Two storey side and rear extension, single storey rear extension & replacement front porch.

28 Arun Road Bognor Regis

Thank you for your internet representation made on 18th November 2019 which has been recorded as '**an objection**' with the comments as follows:

CLIENT	Mrs G Curtis	DRAWING	002 Proposed Plans & Elevations		
SITE	28 Arun Road, Bognor Regis	DATE	31 10 19	AUTHOR	AH
PROJECT	Proposed Extensions & Alterations	SCALE	1: 100 @ A3	STATUS	PRE PL

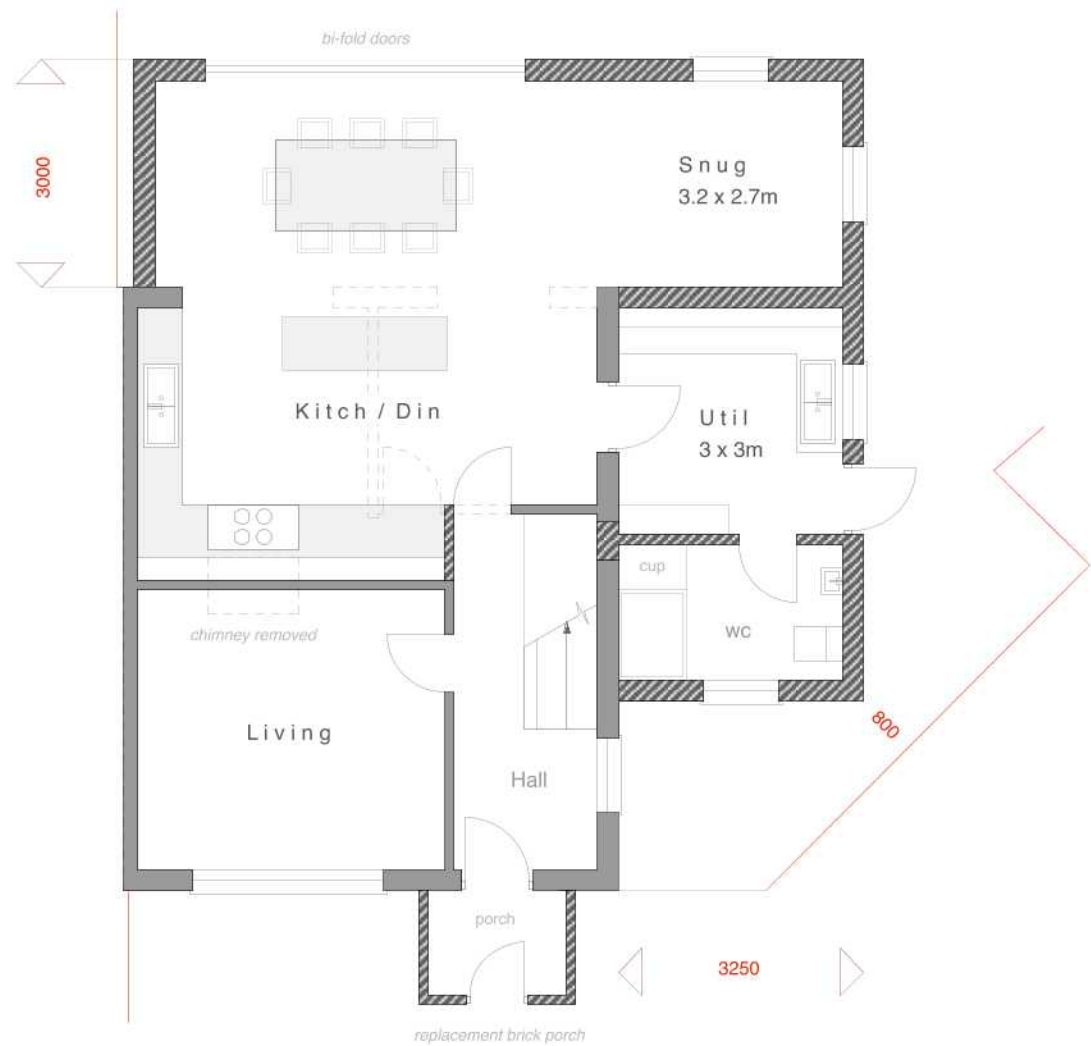
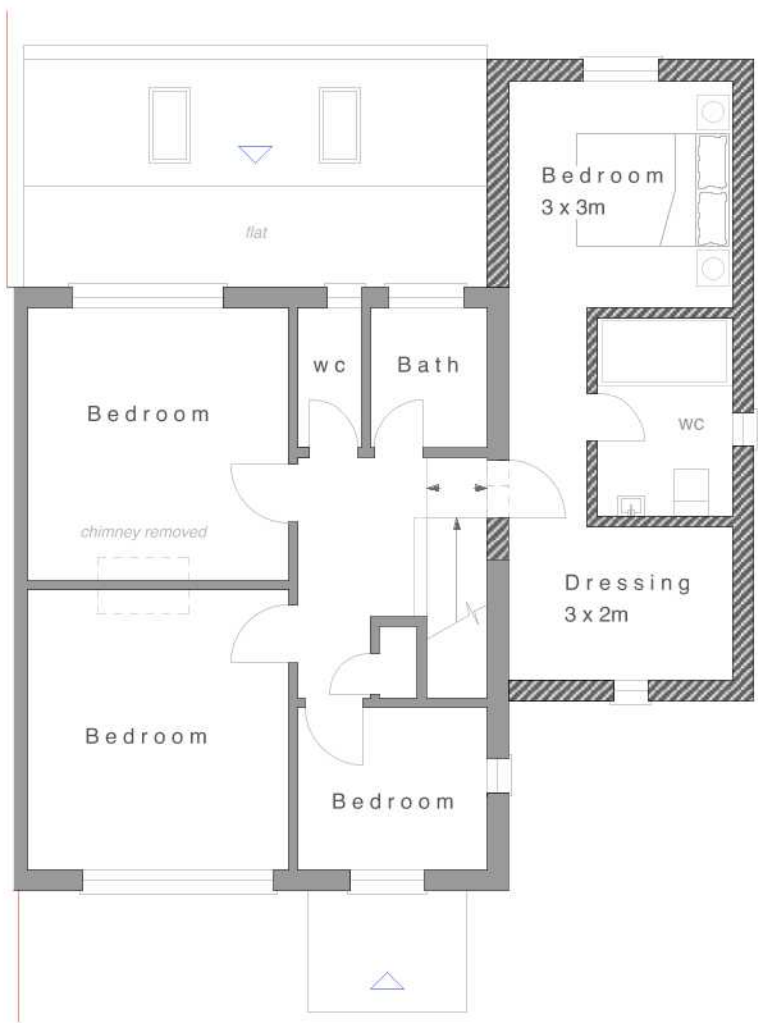
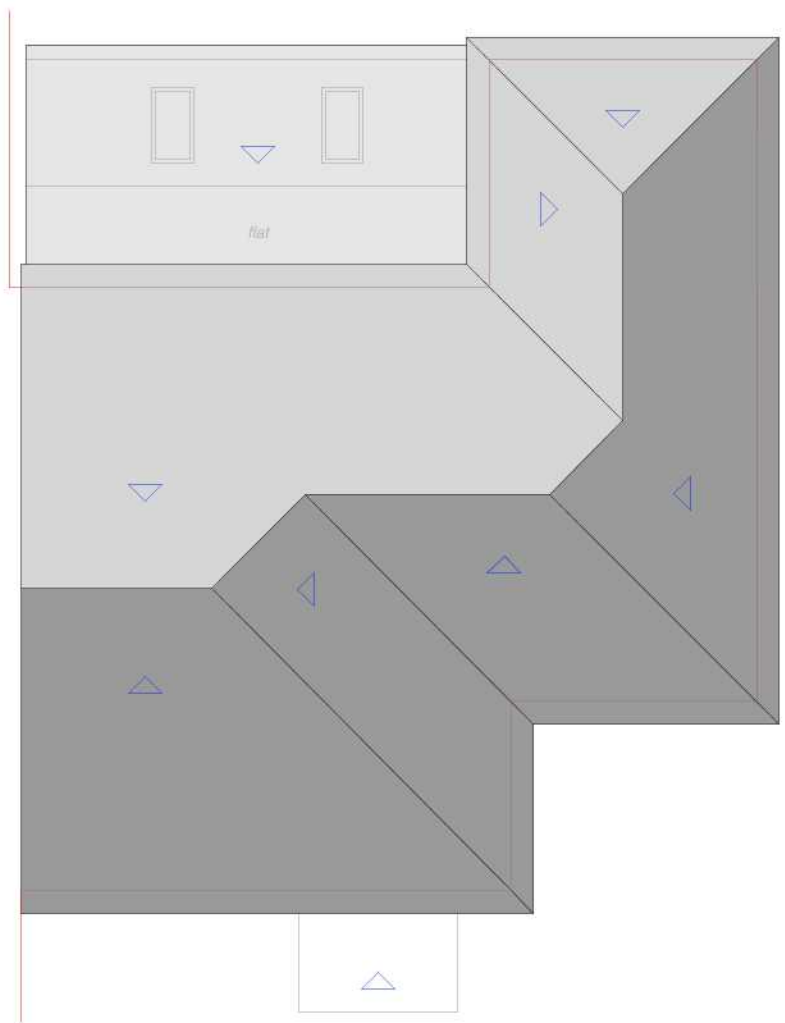
We wish to object to the planning application at 28 Arun Road due to the overbearing and out of character 2 double storey extension's. They will have a detrimental effect on the street scene and the present symmetry of the pairs of semi detached houses in Arun Road.

It will be extremely close to surrounding neighbouring properties, is overbearing and excessive in size by nearly doubling the size of the house. Also other neighbours have had two storey extensions refused previously due to being out of character with the road.
